Permit No: 04-0877	Issue Date: JUN 23 2004	QBL: 339 B021001
-----------------------	----------------------------	---------------------

Location of Construction: 126 Harris Ave	Owner Name: Larochelle Catherine C &	Owner Address: 126 Harris Ave	Phone: () 797-7127
Business Name:	Contractor Name: self	Contractor Address: Portland	Phone:
Lessee/Buyer's Name	Phone:	Permit Type: Swimming Pools

Proposed Use: Single Family w/24' x 52" above ground pool & 12' x 42' deck on grade	Proposed Project Description: New installation after damage, 24' x 52" above ground pool w/ 12' x 42' deck on grade
---	---

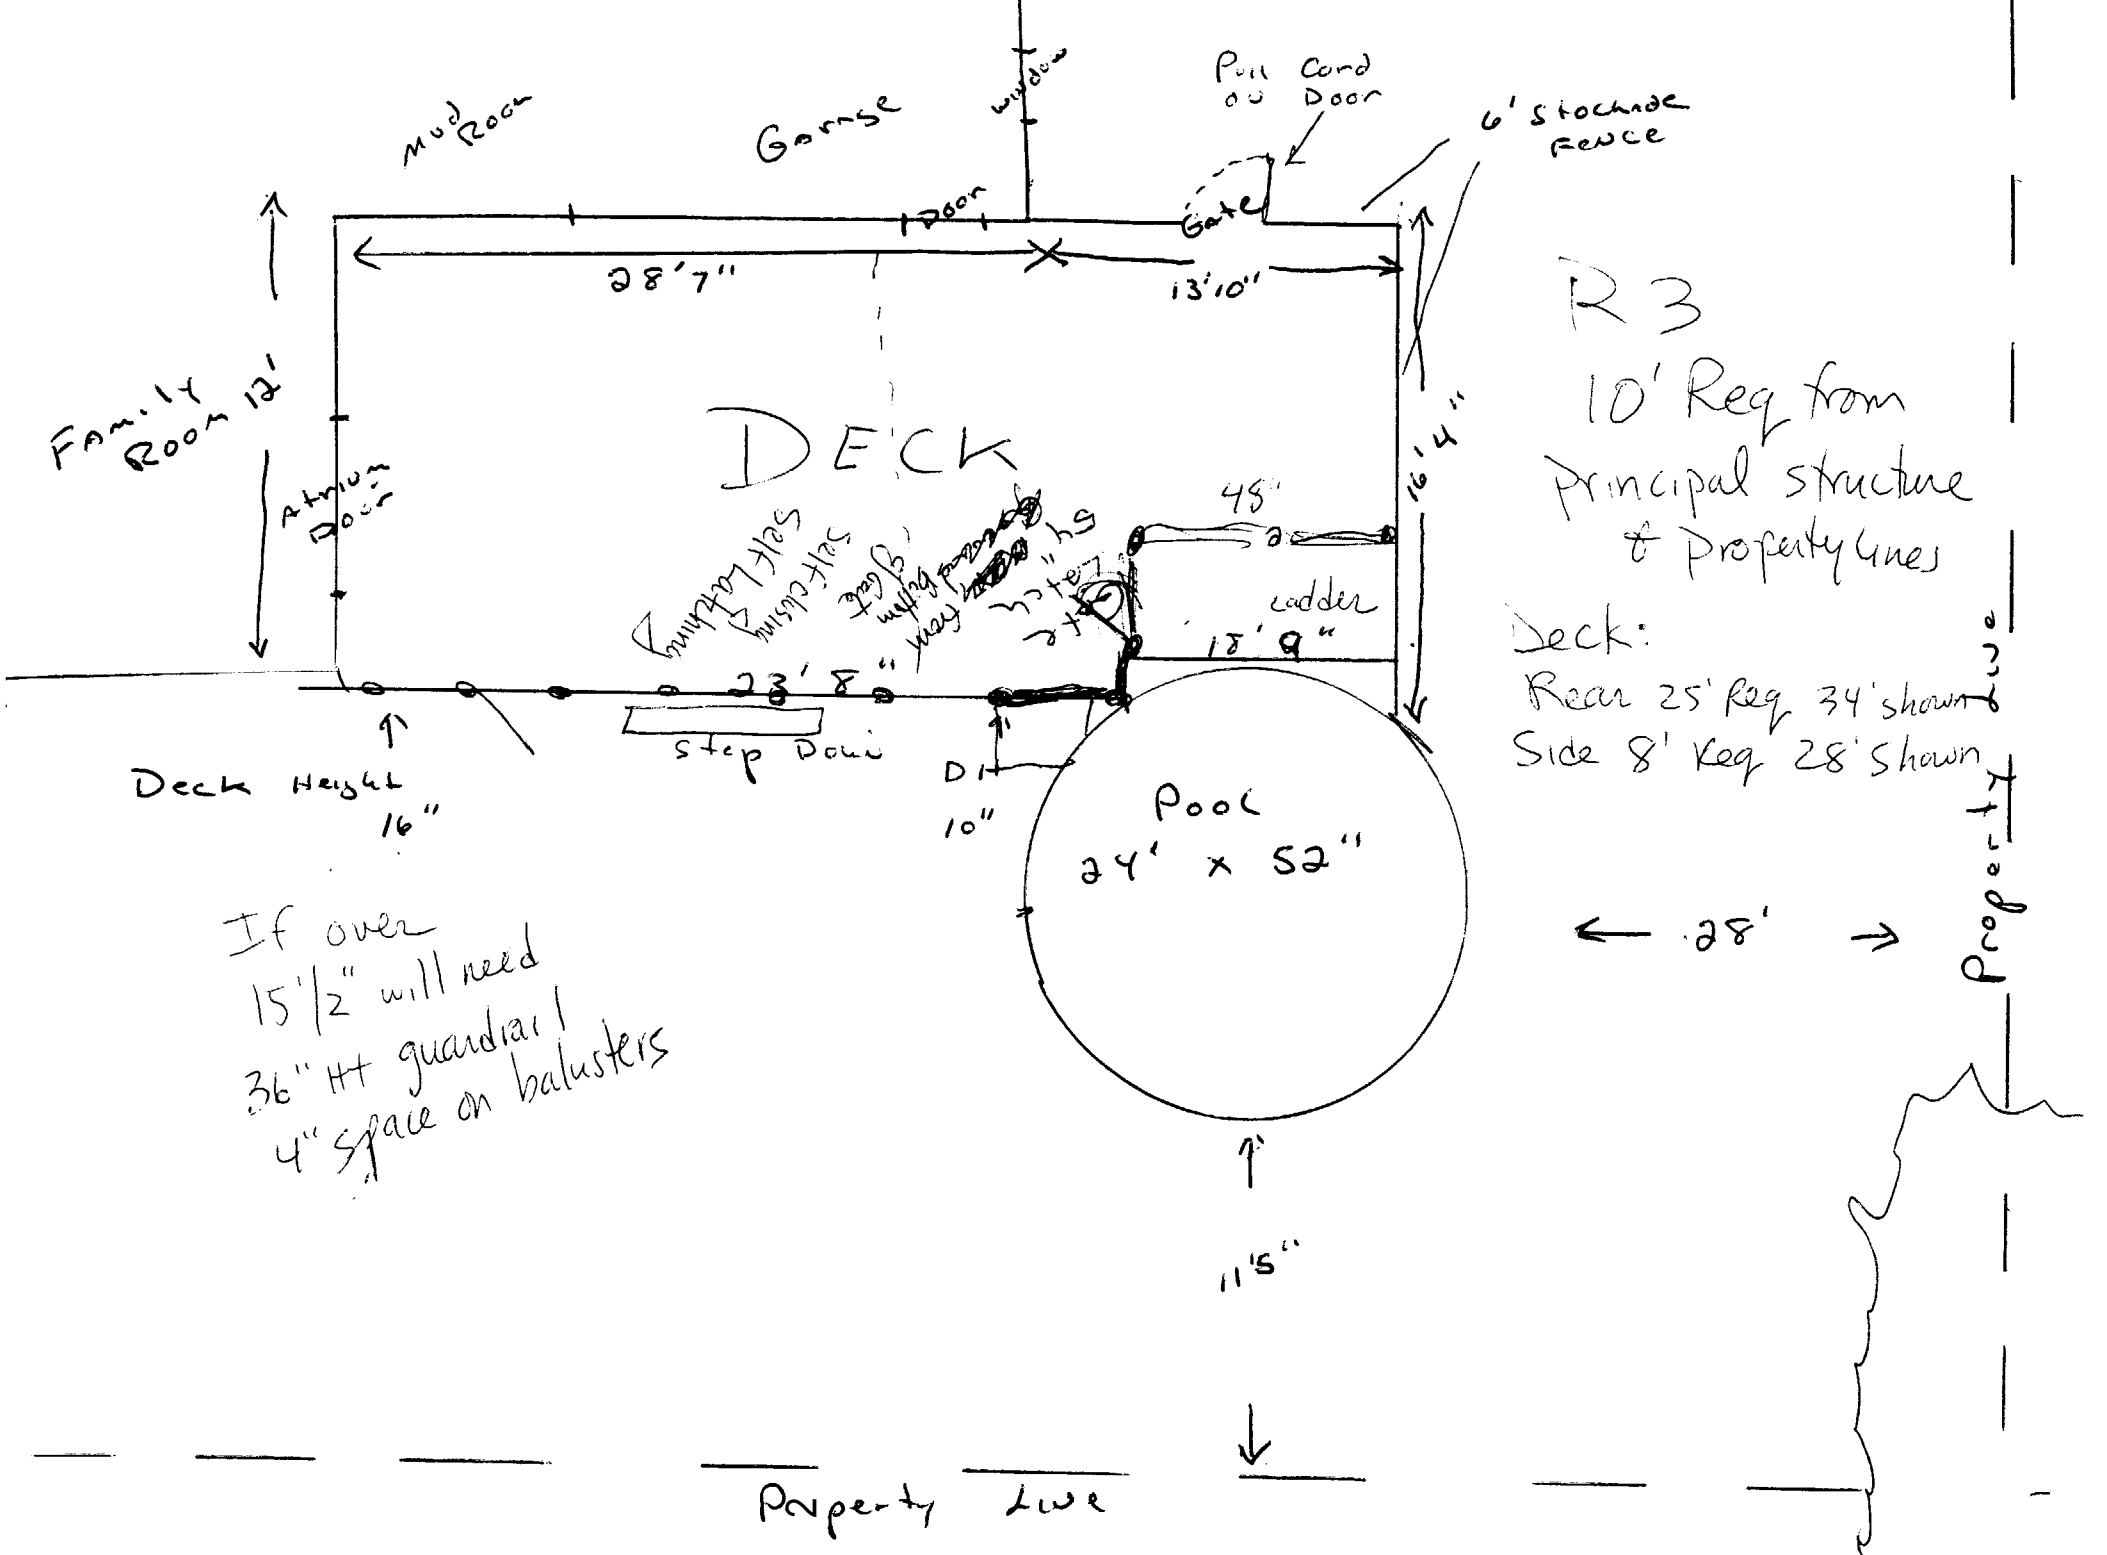
Dept: Building	Status: Approved	Reviewer: Jeanine Bourke	Approval Date: 06/28/2004
Note:			Ok to Issue: <input checked="" type="checkbox"/>
1) K. Carroll responded to a complaint, sona tubes already installed @ 4' + per owner			
2) Ladder barrier protection must be installed per Sec. 421 of the 1999 BOCA code
